WEST SUSSEX COUNTY COUNCIL CONSULTATION

TO:	Arun District Council FAO:Simon Davis
FROM:	WSCC - Highways Authority
DATE:	9 October 2019
LOCATION:	The Former Ship Inn Aldwick Street Aldwick PO21 3AP
SUBJECT:	AW/237/19/PL Application for variation of conditions imposed on planning reference AW/211/14/PL relating to condition 8 - delivery times & Condition 10 - delivery of goods serving the store in accordance to the Delivery Management Schedule. More information.
DATE OF SITE VISIT:	
RECOMMENDATION:	No Objection
S106 CONTRIBUTION TOTAL:	n/a / £ See below for breakdown.

Client
One Stop Stores Limited
Project
The Former Ship Inn, Aldwick Street, Bognor Regis. PO21 3AP
Title
Site Location Plan with Vehicle Tracking : Articulated Vehicle
Scale
1:500 @ A1
Date
07.01.2020
Drawn By
PAL
Checked By
PM
Project No:
B190031
Drawing No:
B 202
Revision
A

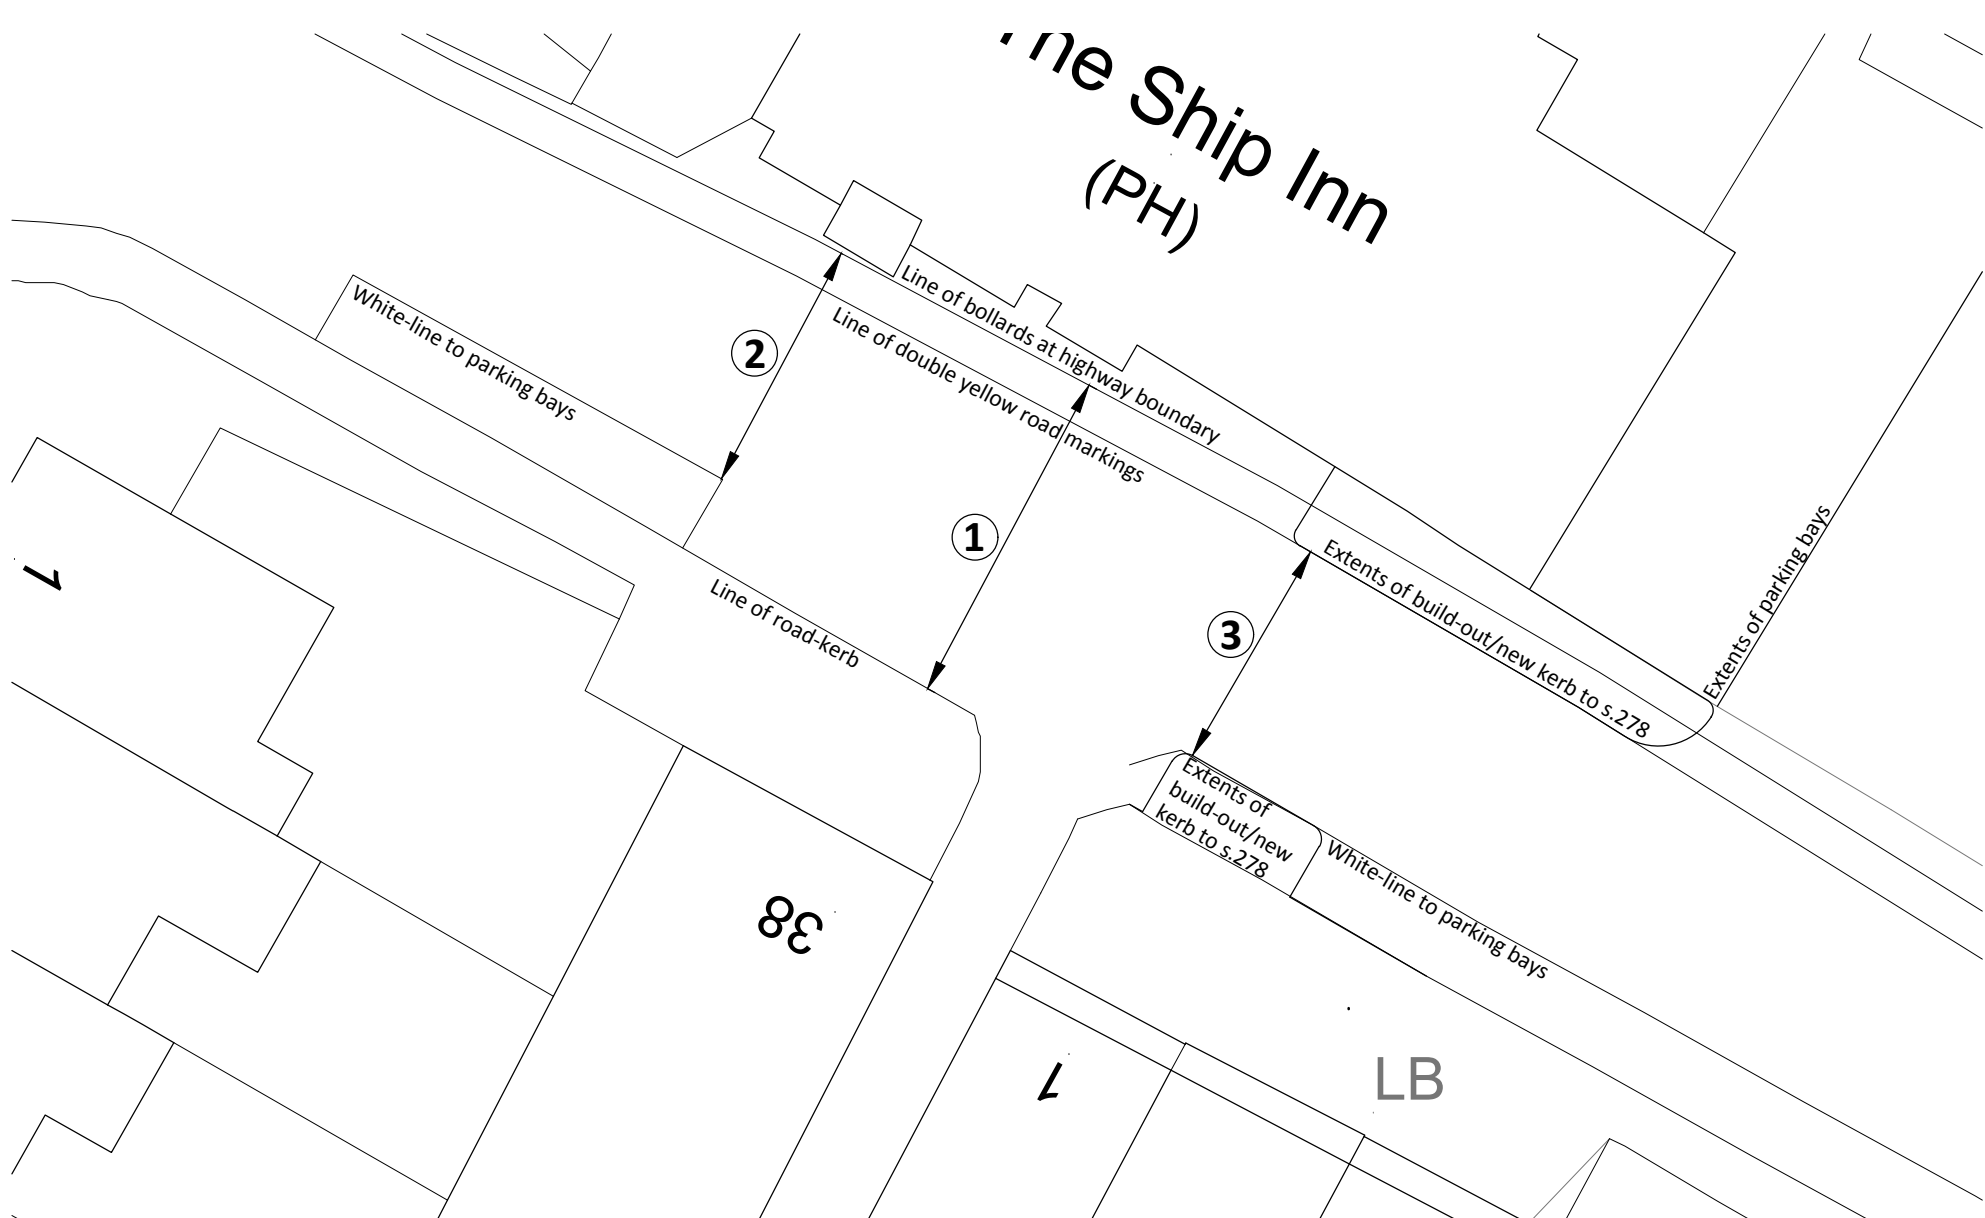
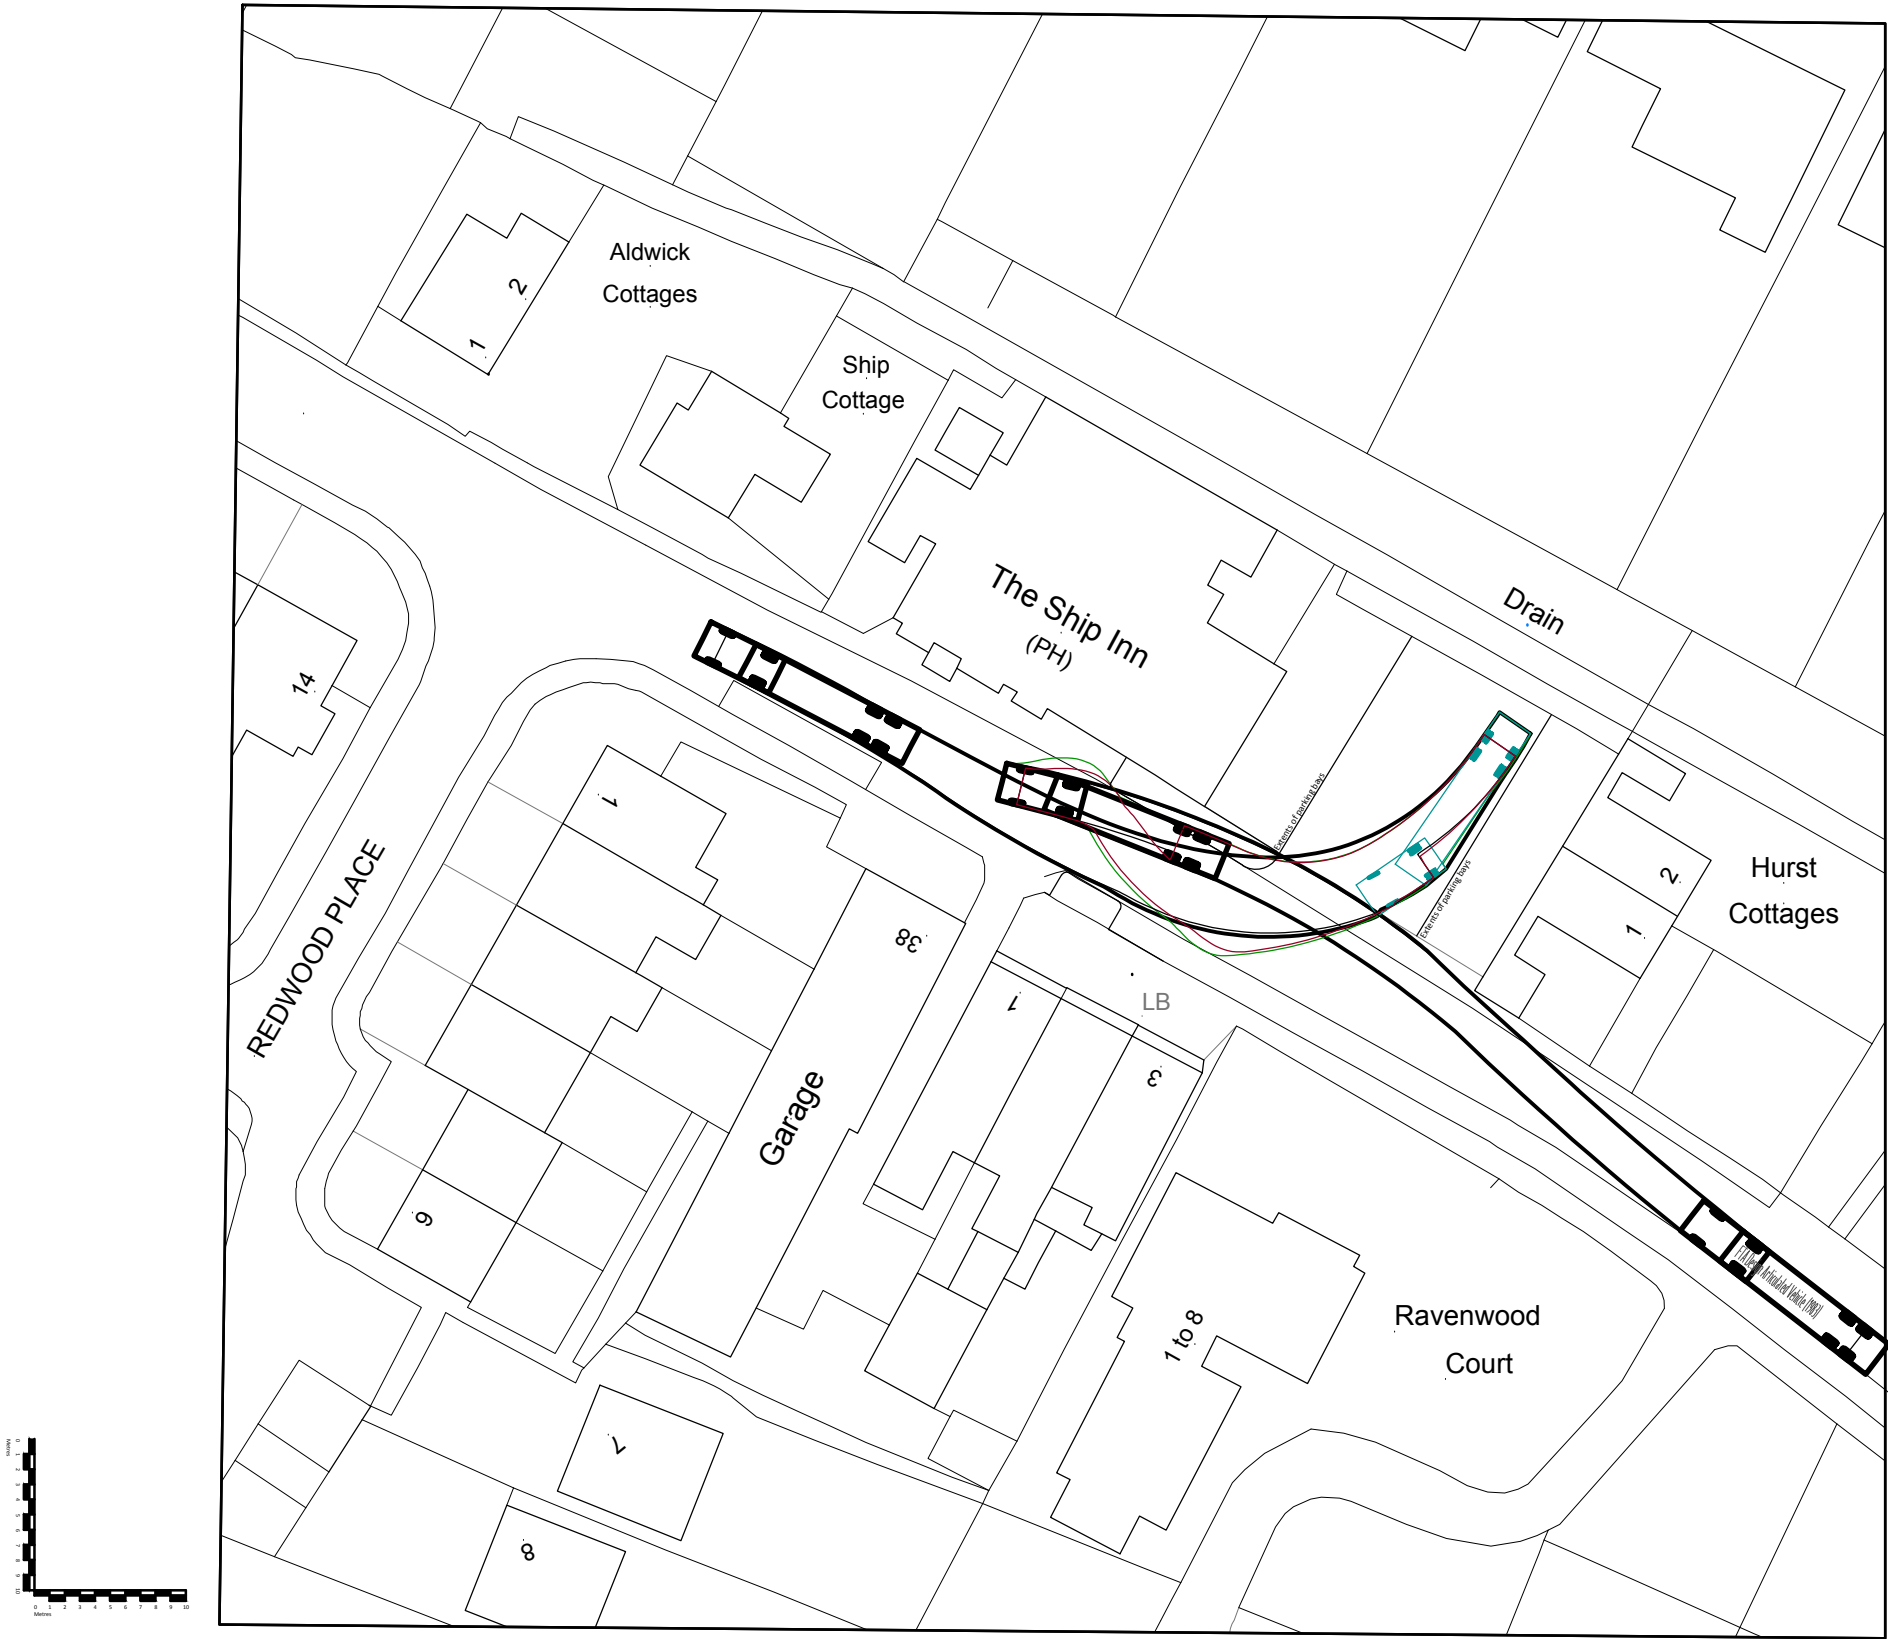
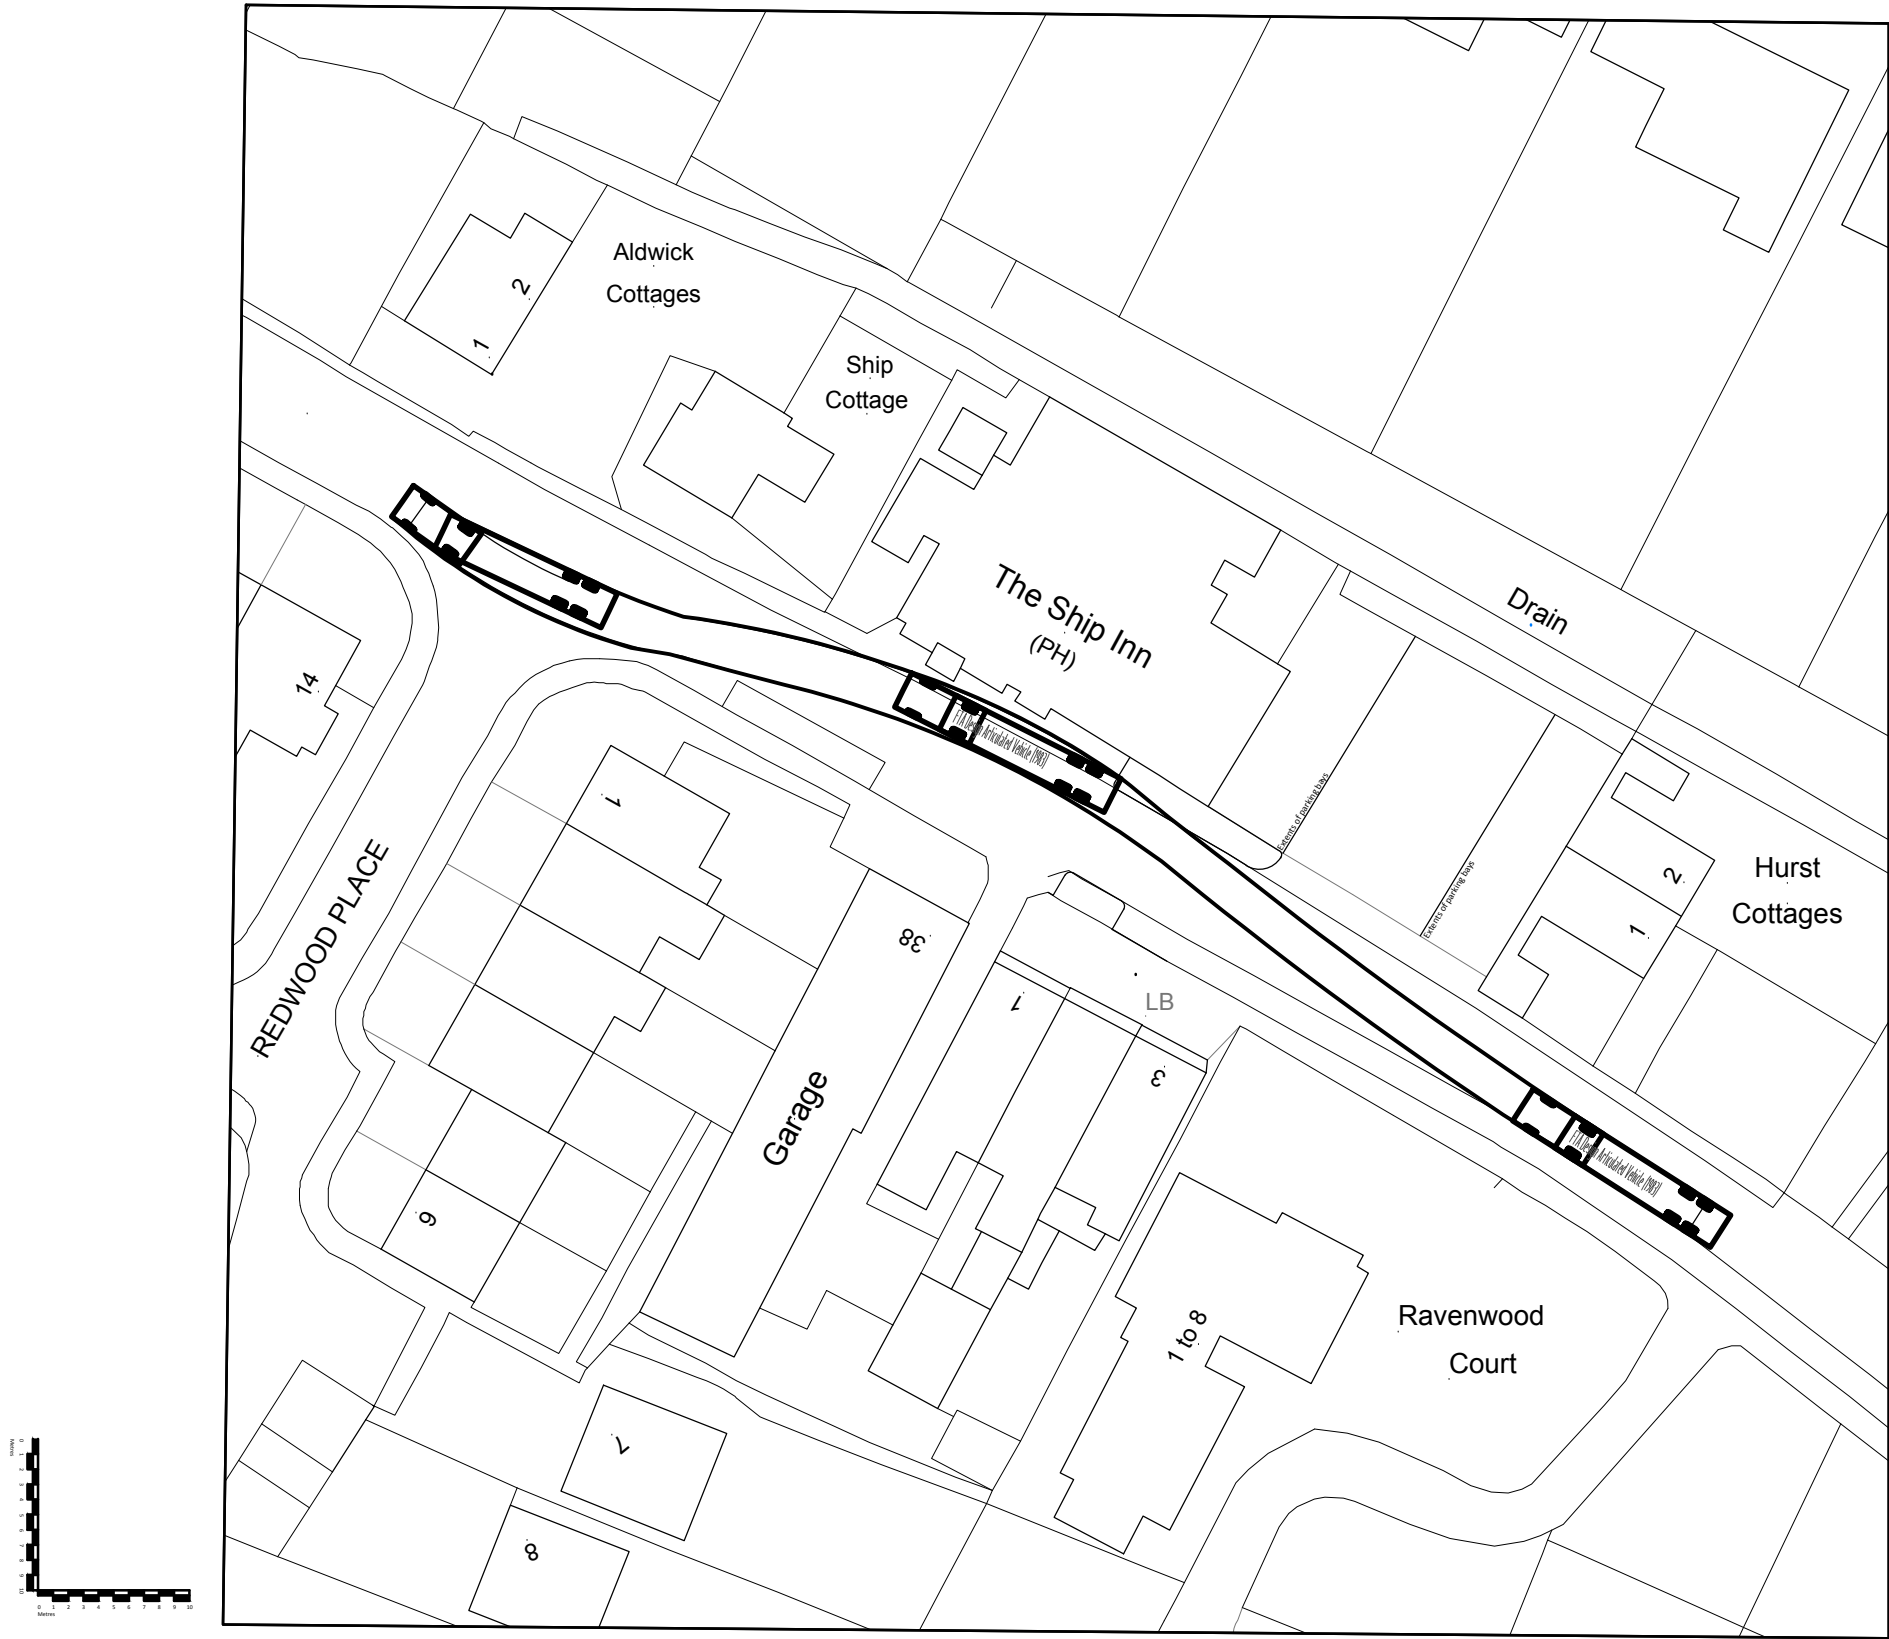
In all instances should a delivery get caught in traffic and arrive or depart when it would not be practical to use the car park; the applicant has shown that a vehicle can wait within the highway, albeit a tight manoeuvre, and the swept paths provided in drawing (B 104) evidence that two cars can pass each other when the HGV is stationed in this position.
